Engineers Comments Regarding Surface Water Drainage

Application Reference:	P/84/26/DOC	Reviewer Reference:	ADC/EXT4b
Planning Officer:	Hannah Kersley	Date of Review:	10/08/2026
Site Name:	Land North of Hook Lane Pagham		
Application Description:	Approval of details reserved by condition approved under P/149/23/S73 relating to condition 12b-as built drawings of fully implemented scheme with completion report.		
Assessment Number:	1

Headwall Details
Sheet 1

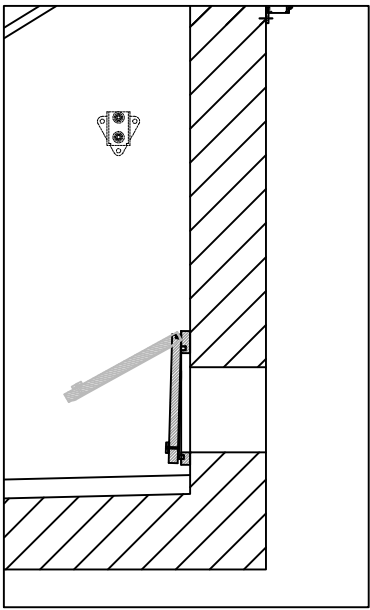
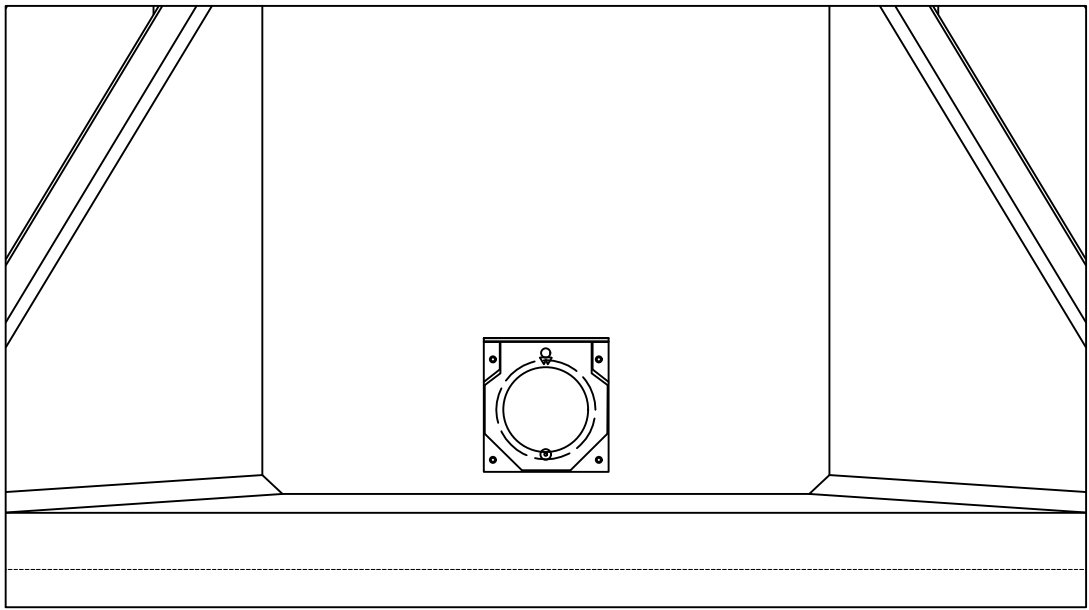
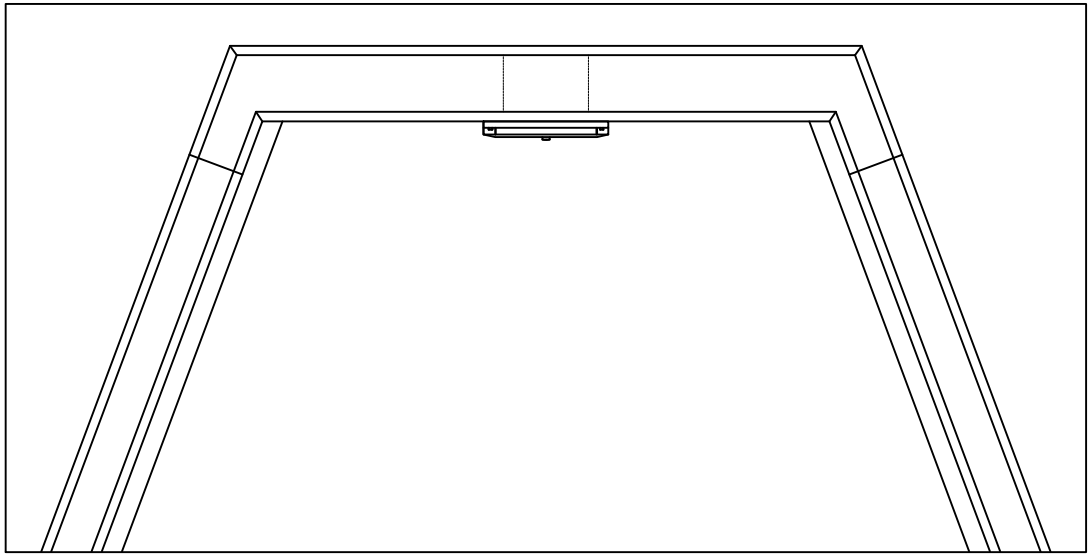
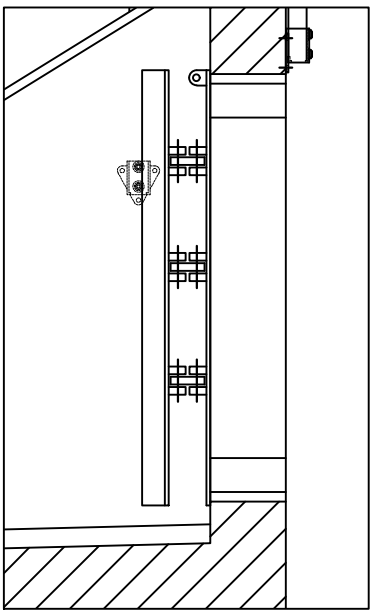
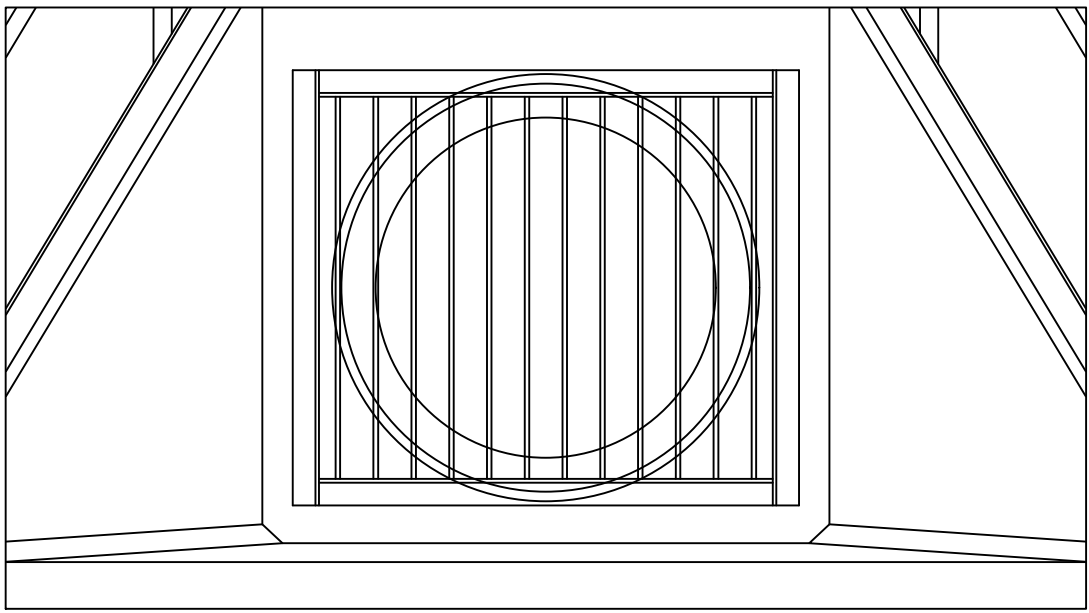
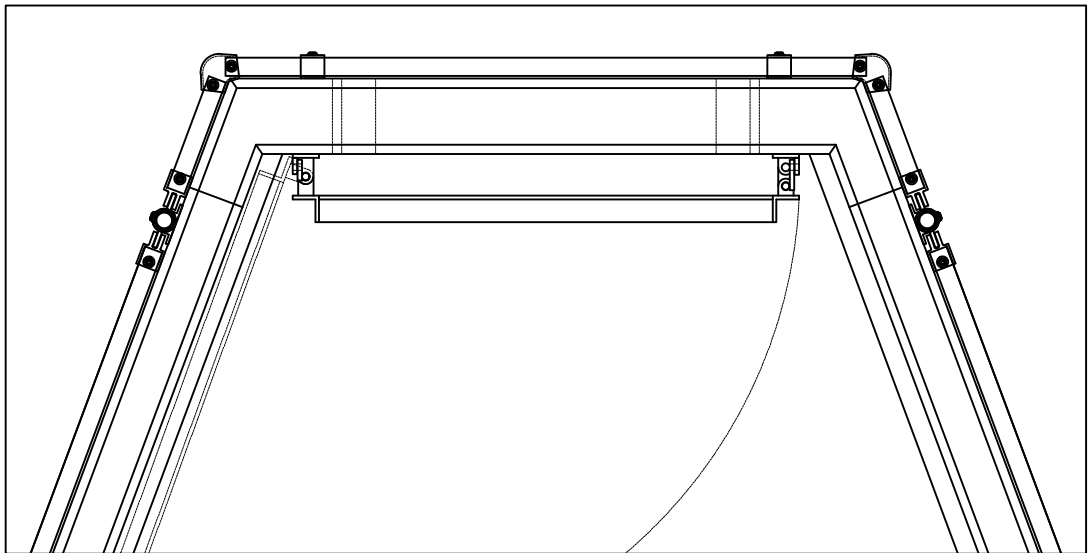
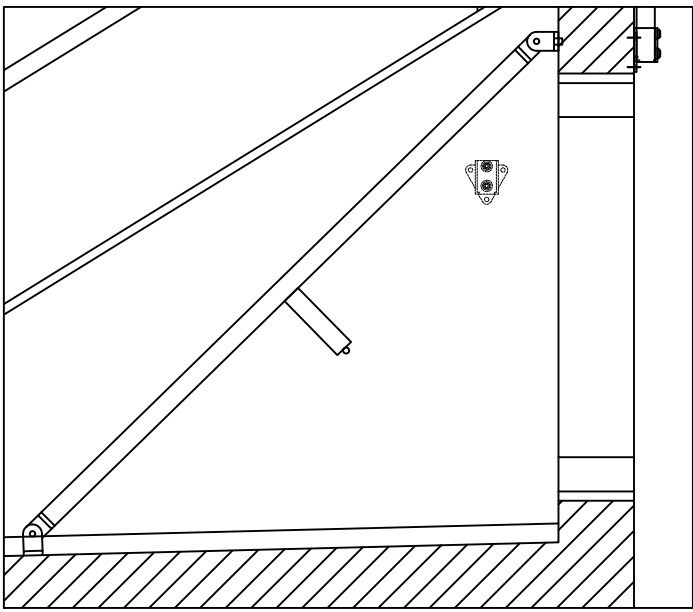
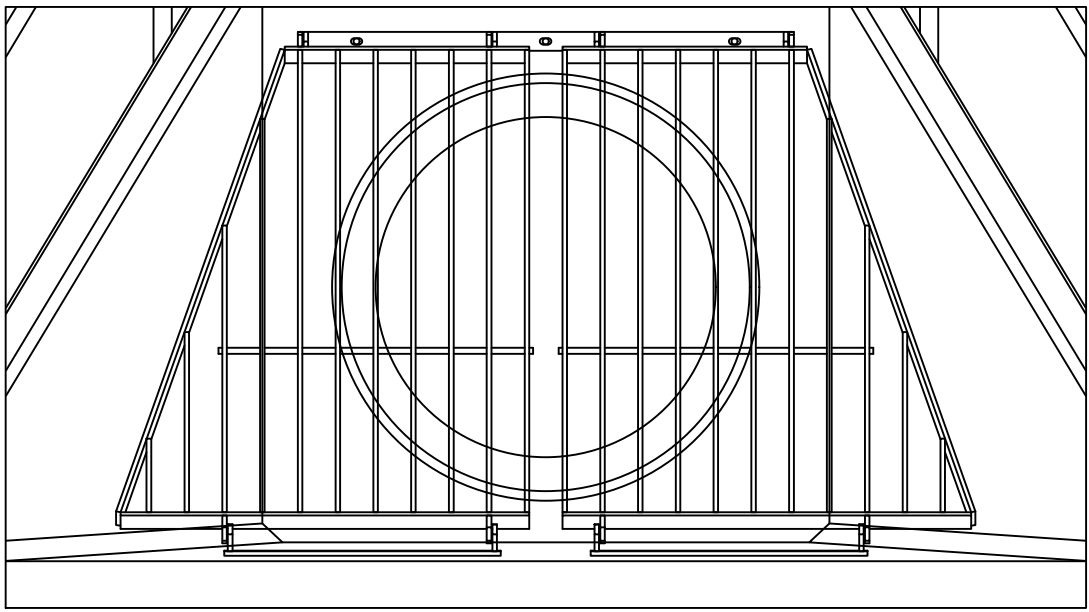
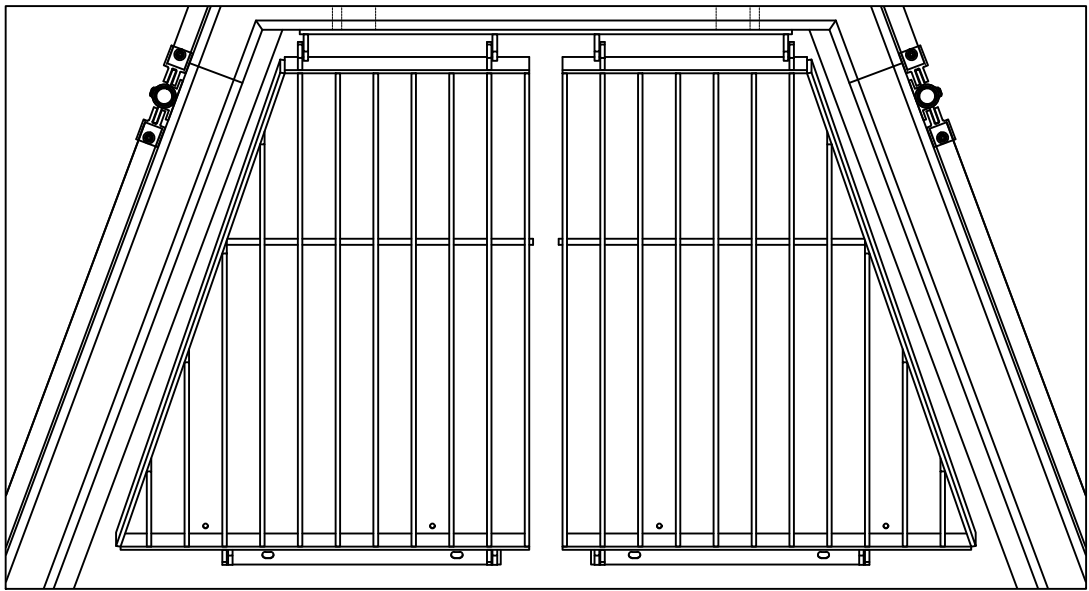
indemnity insurance for the verification works provided.				
3.	An inspection was undertaken in October 2025 and it appears no further visits have been made to site. The inspection was unable to include verification of key elements and as such the author relies upon information supplied by the contractor, some of which is still unknown or uncertain. Further inspection by the author is necessary to verify the drainage.	An additional site visit has been undertaken on 15 April 2026. The inspection seems to be limited to collection of site photographs, with the developer Bellway Homes supplying the drainage survey. Photographs demonstrate that the design has not been installed as approved including missing headwall(s) and flow controls.
